Your Ref: OWPC20922
Our Ref: K/40/18/PL 14-11-2018
Please ask for:
Mrs A Gardner

Demolition of existing dwelling & erection of 1 No. dwelling, associated landscaping & parking (resubmission following K/11/16/PL).

Spring Tide Gorse Avenue East Preston

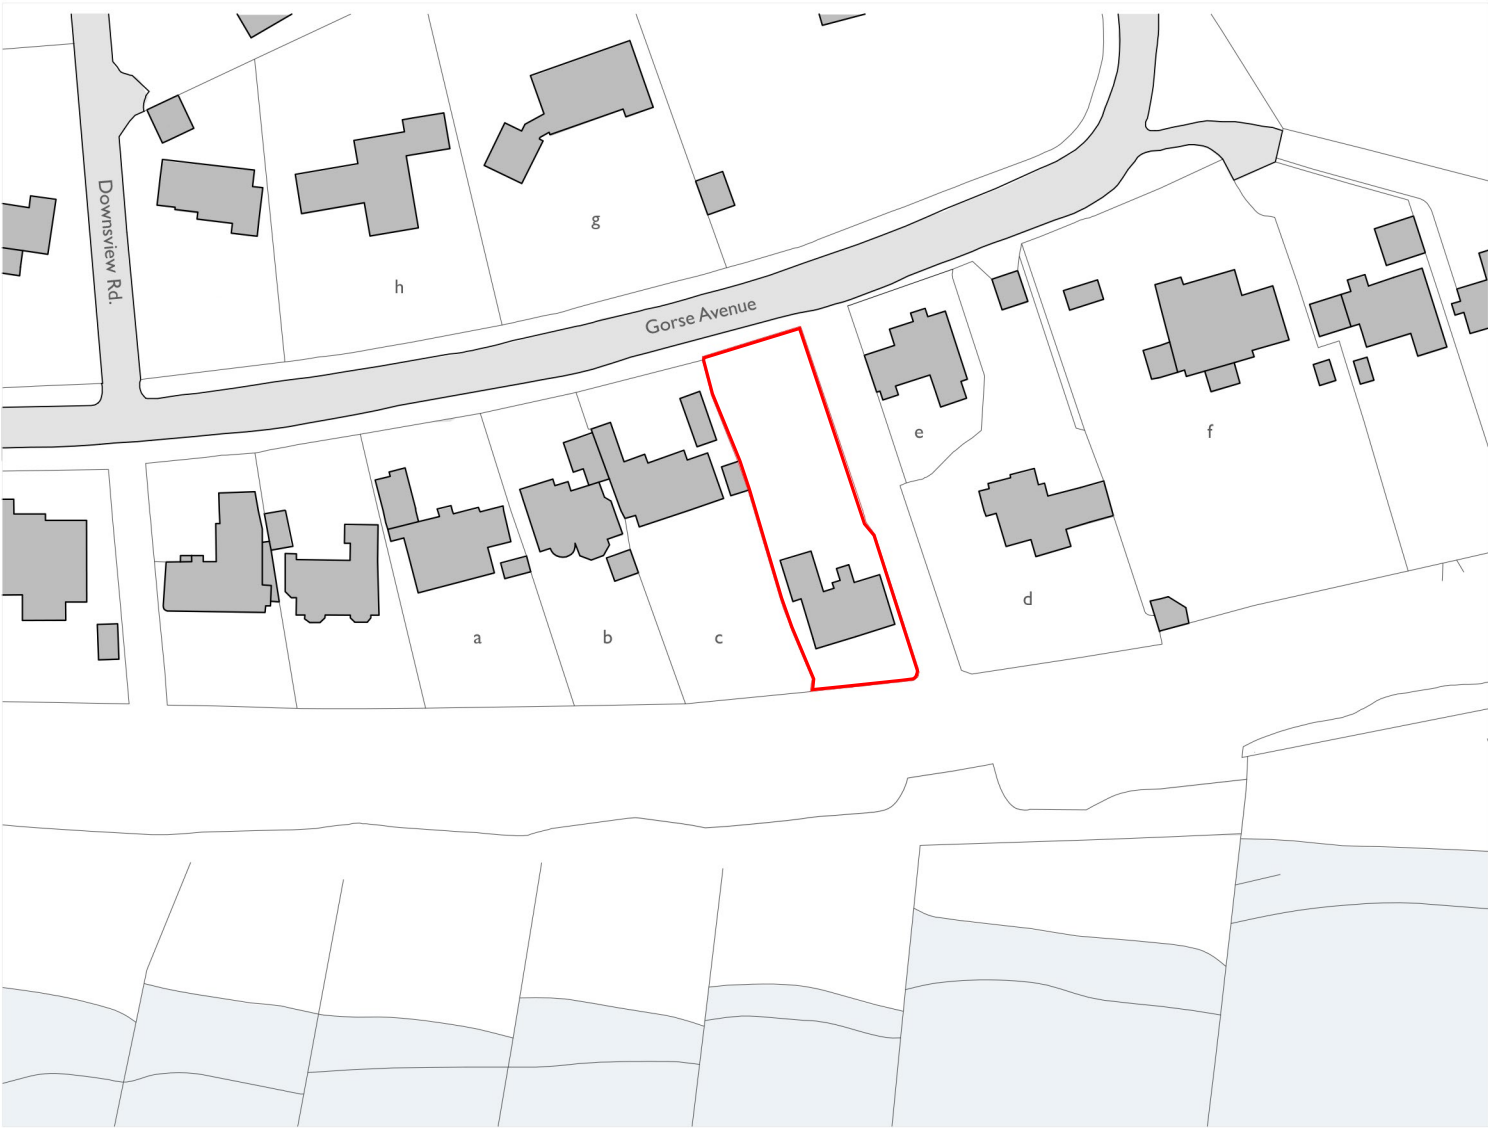
- 2. Building Line: The garage is in front (north) of the general building line in Gorse Ave.*
- 3. Height: The flat roof is 100mm higher than the adjacent ridges.*

- 4. Over-development of the site: The ground floor foot print is significantly larger than the existing building and may be considered to be an over development of the site as it covers approx. 55 - 60% of the site which is significantly higher than that on the adjacent properties.*
